Project name	A38 Derby Junctions Improvement
File reference	TR010022
Status	Draft
Author	The Planning Inspectorate
Date	12 February 2019
Meeting with	Highways England
Venue	Teleconference
Meeting objectives	Draft Documents Feedback Meeting
Circulation	All attendees

A38: Comments on draft documents, February 2019

Drawing Title
**WORKS PLANS
REGULATION 5(2)(j)
SHEET 2 OF 4**

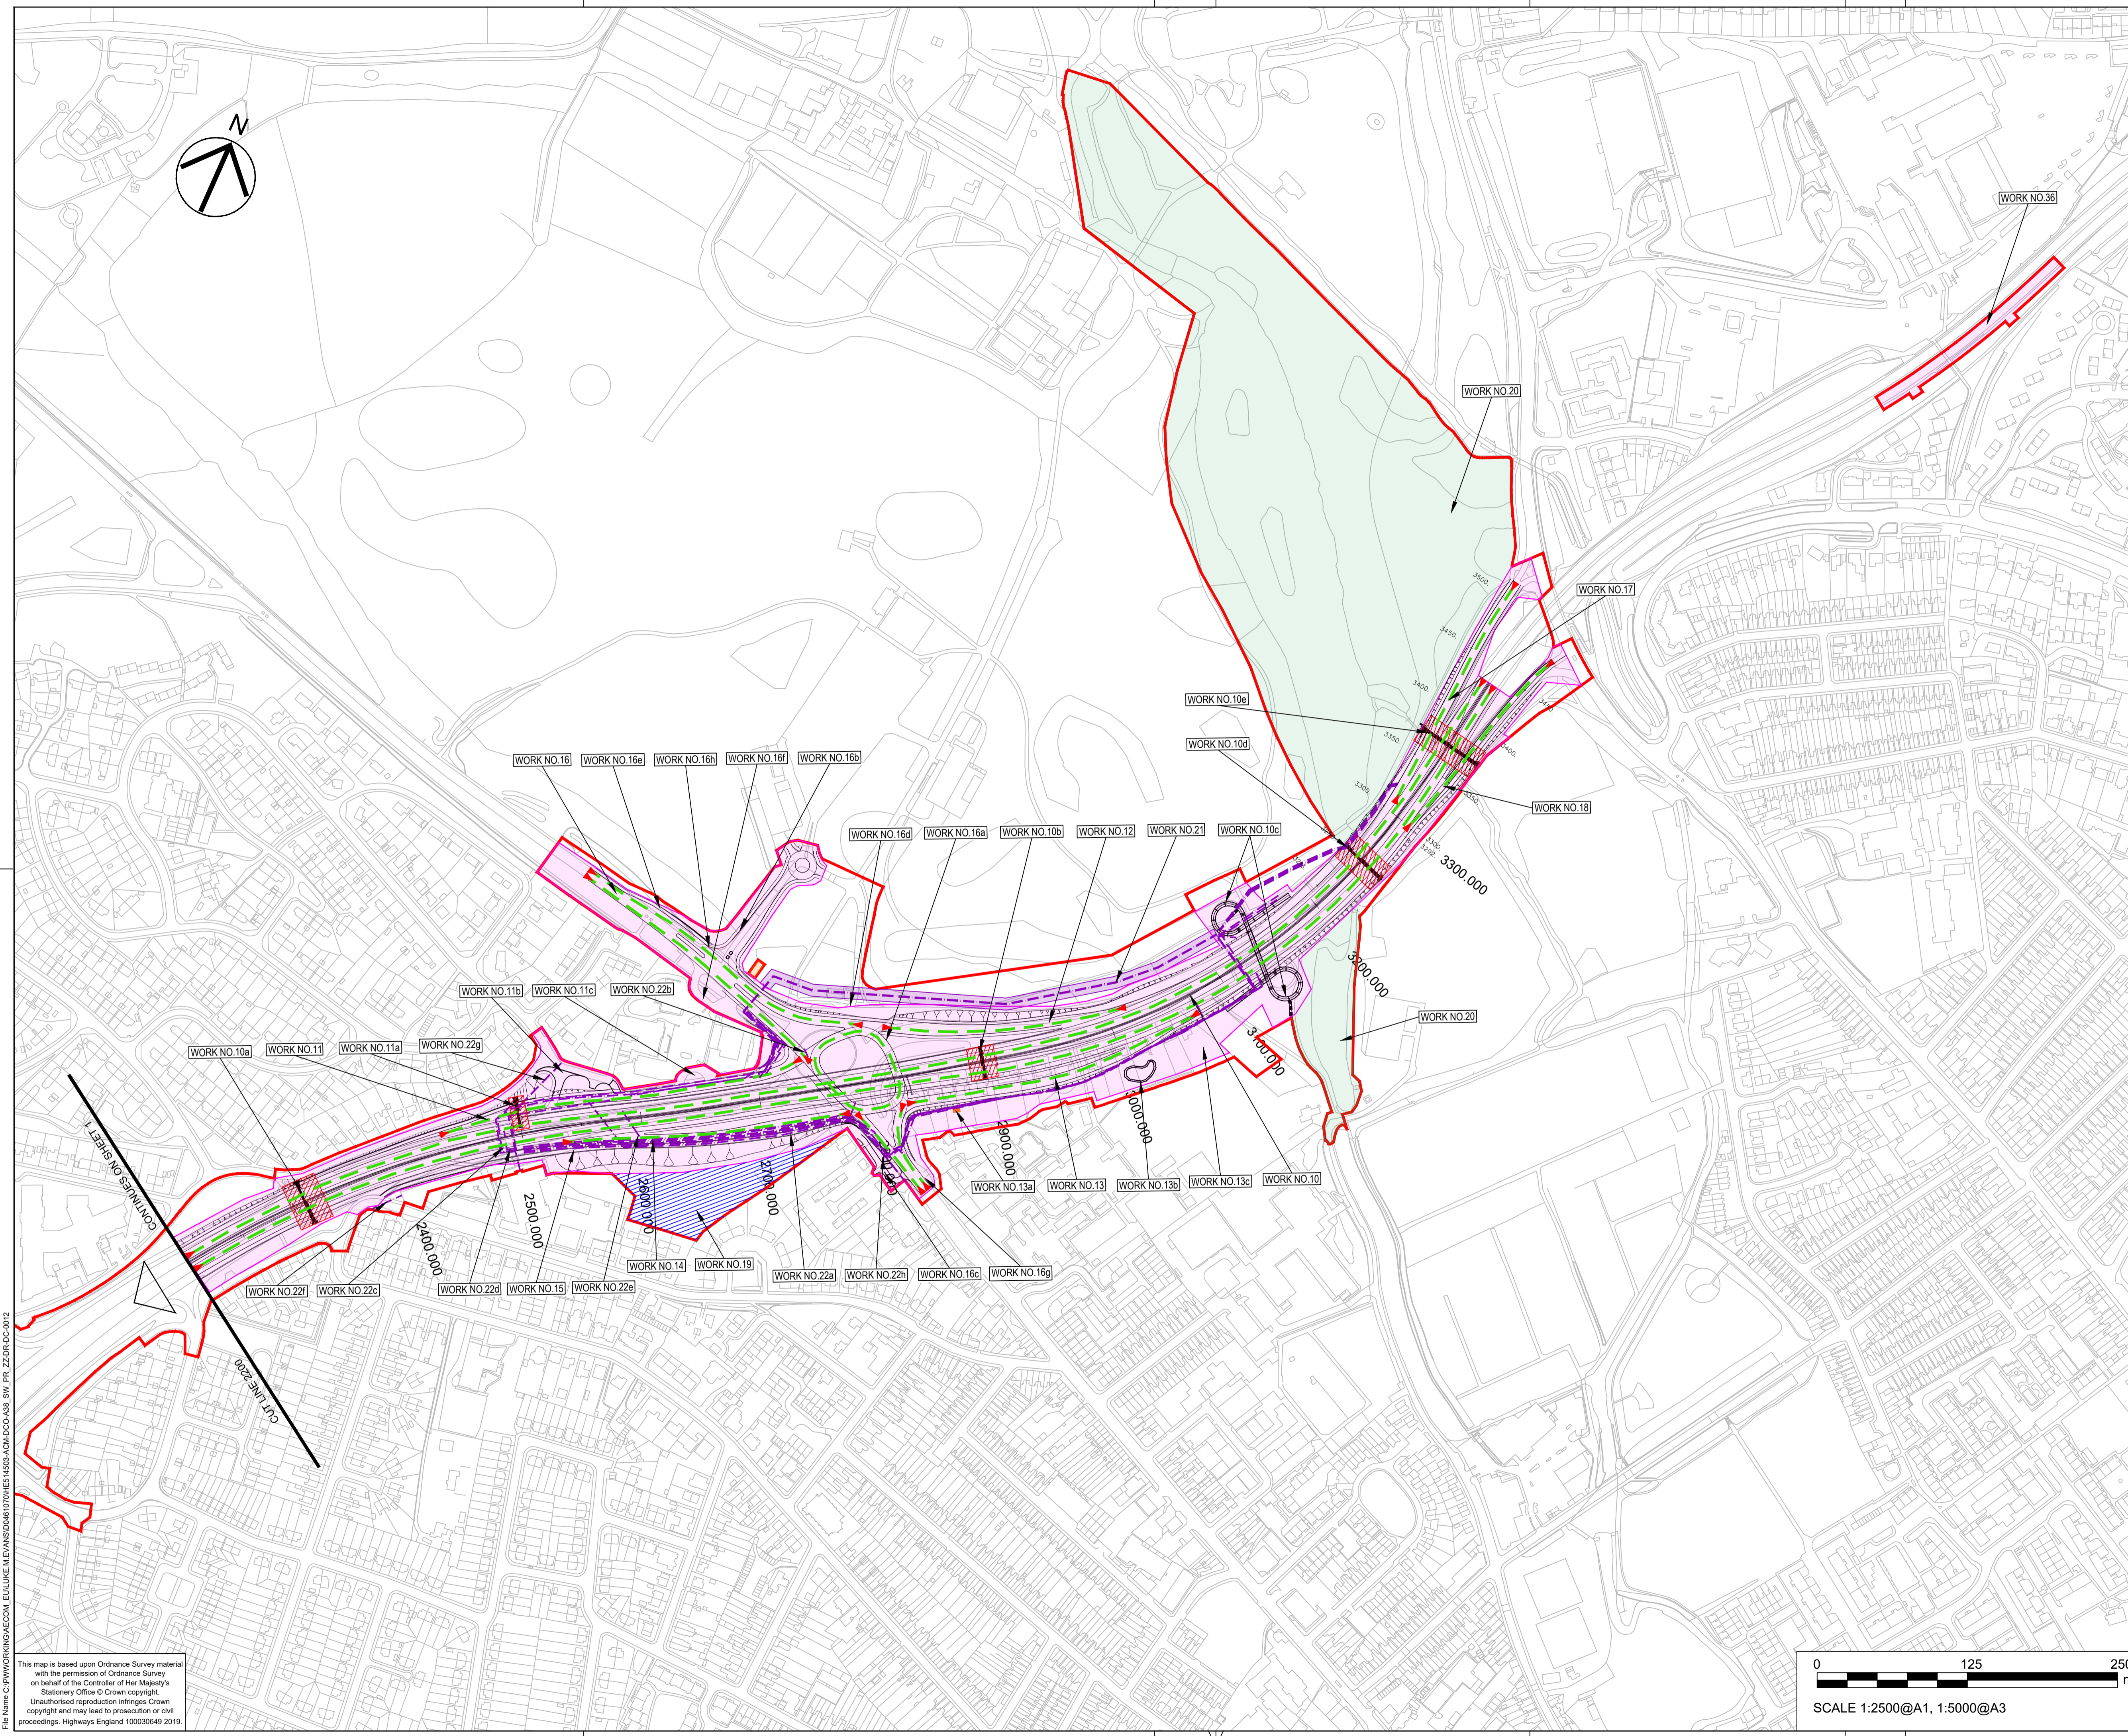
Q No.	Section	Extract from Document	Question/Comment
1	Sheet 2 / Sheet 4 inset A		A cutline or inset box here would assist the legibility of the plans.
2	Sheet 2	<i>e.g. Work 19a shown on Works Plan sheet 2 but DCO states Work 19 not used</i>	There are potential inconsistencies between Works Plans and DCO drafting
3	Sheet 2		There appear to be unshaded unnumbered areas, where no work is proposed, but which lie within the order limits
4	Sheet 3	<i>Work No 31</i>	The limits of deviation of this work are not shown.
5	Sheet 3		Works extend outside the order limits to the north.
6	Sheet 3		Is it clear where Work 33 starts and ends and where Work 29 starts and ends?

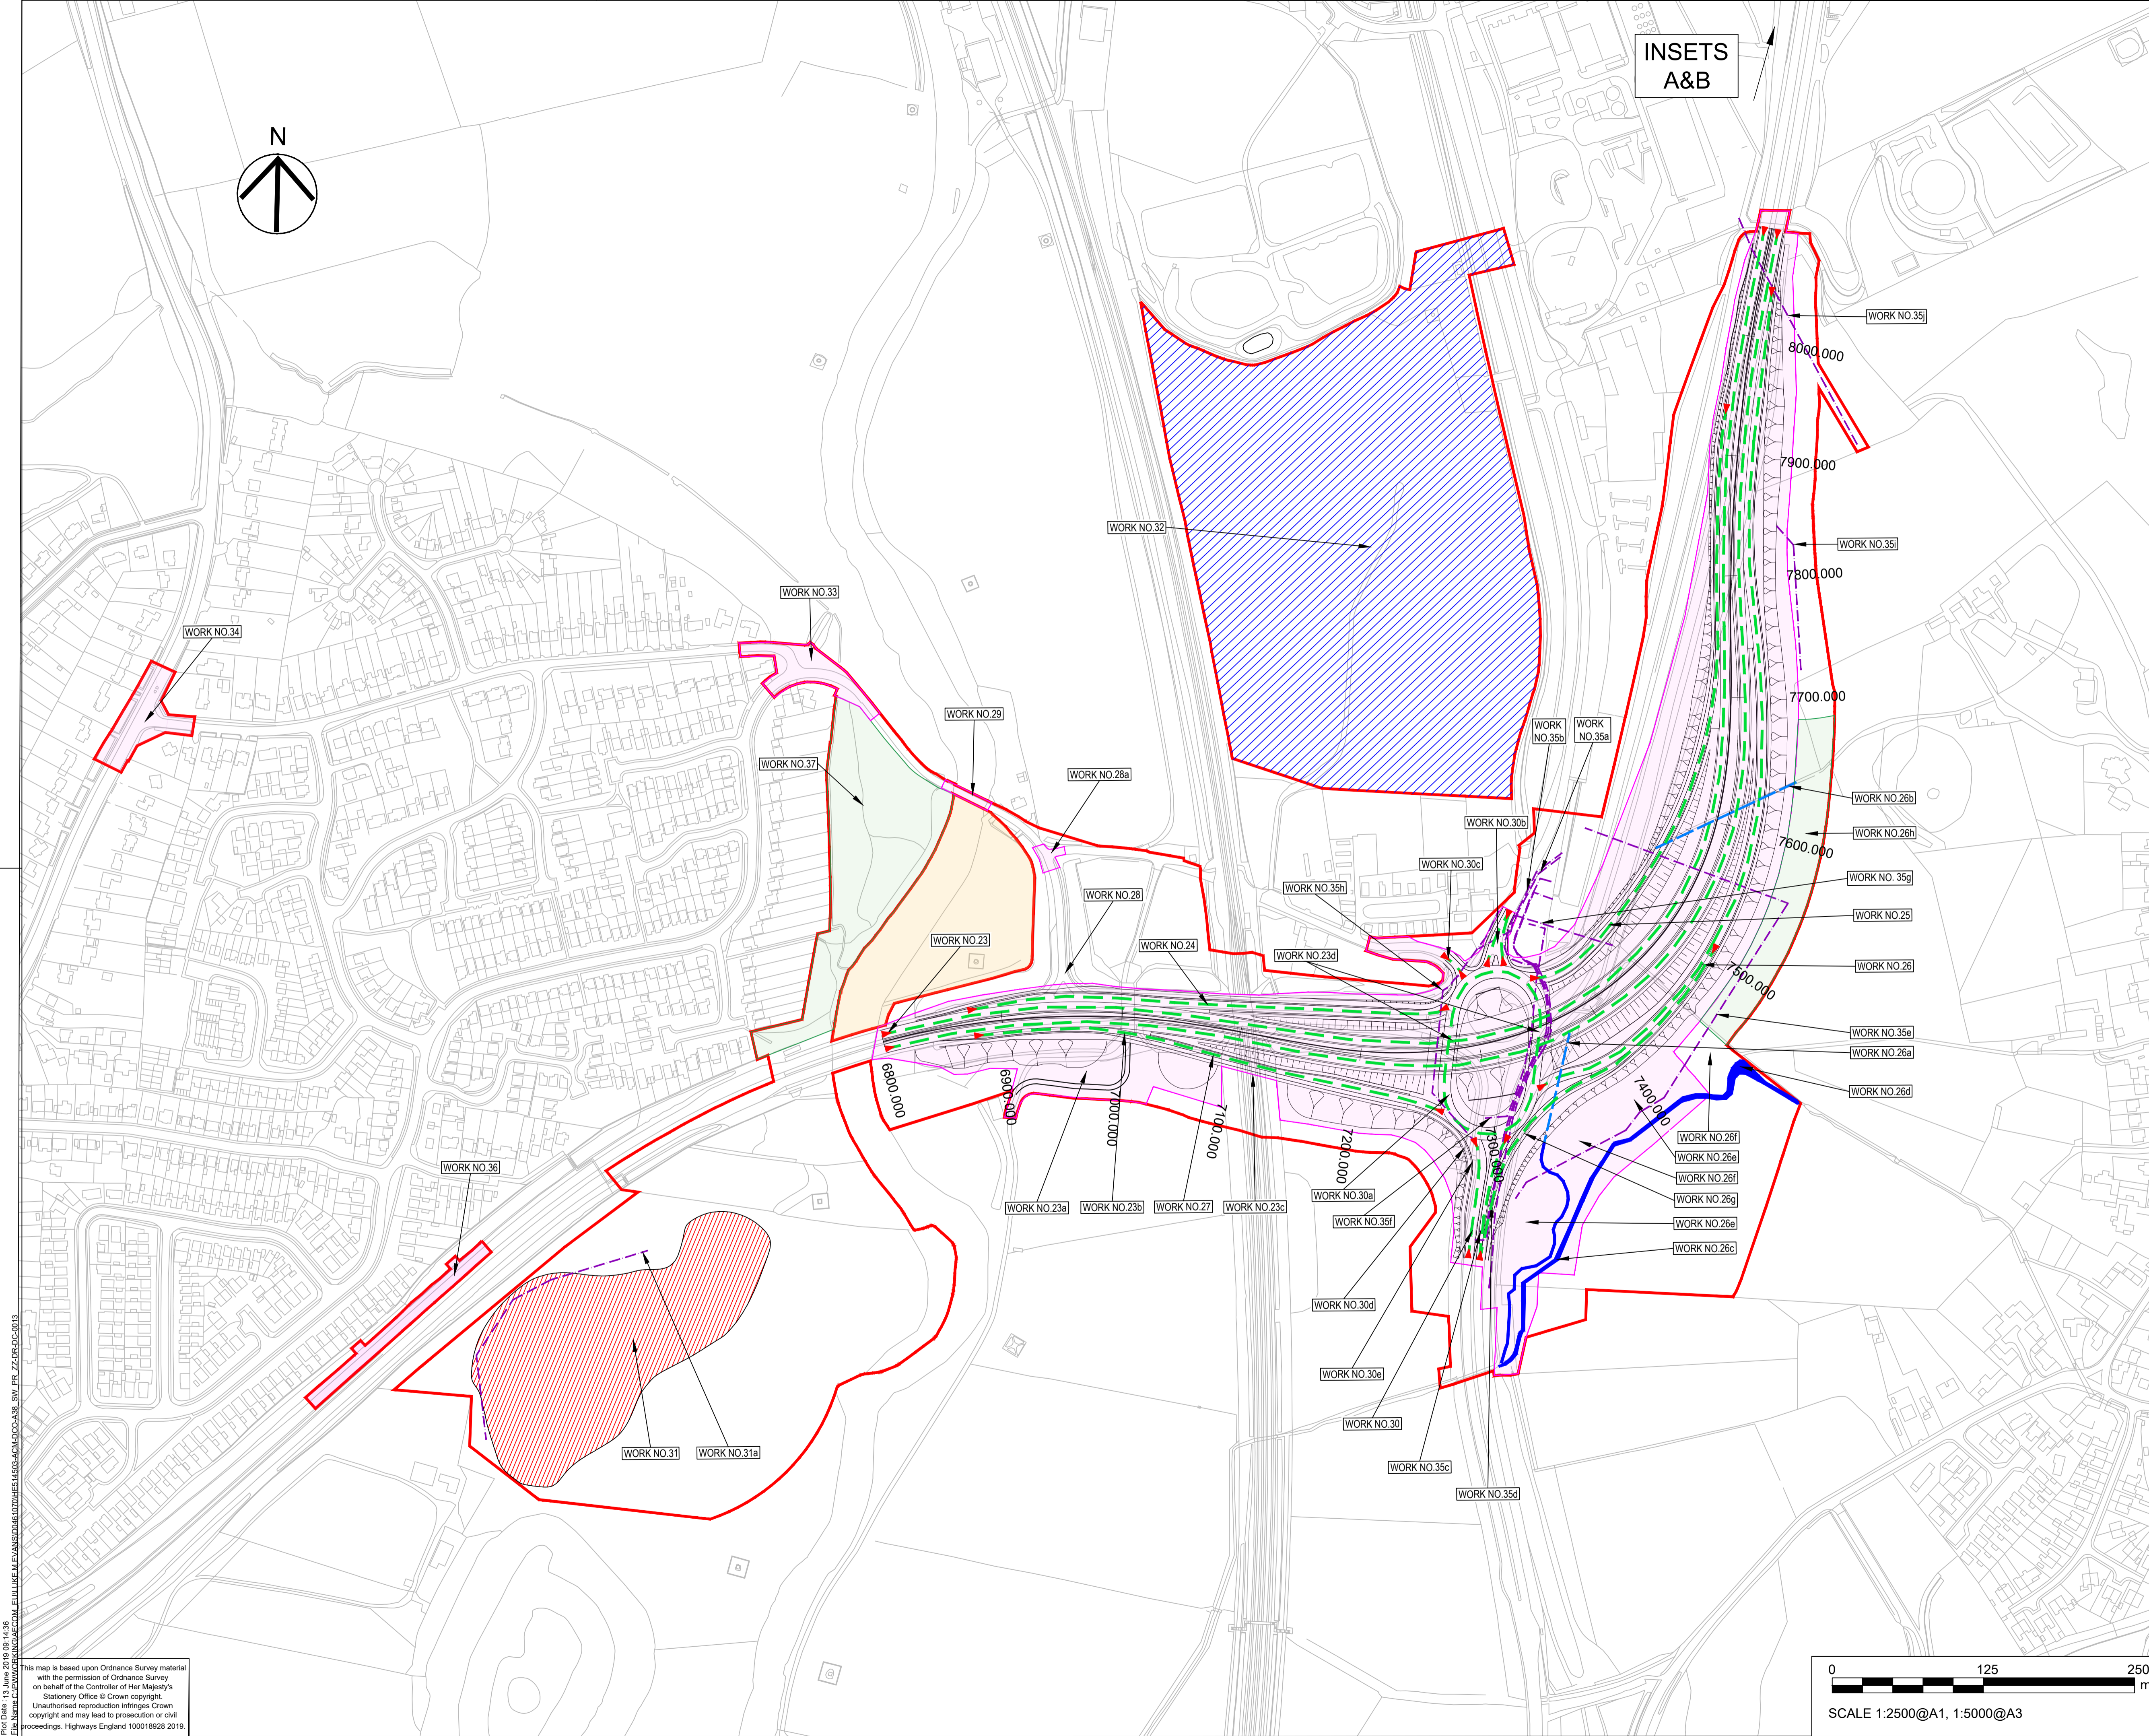
In respect of the Works Plans, it was confirmed that the reference to sheet 2 at point 1 should be a reference to sheet 3.
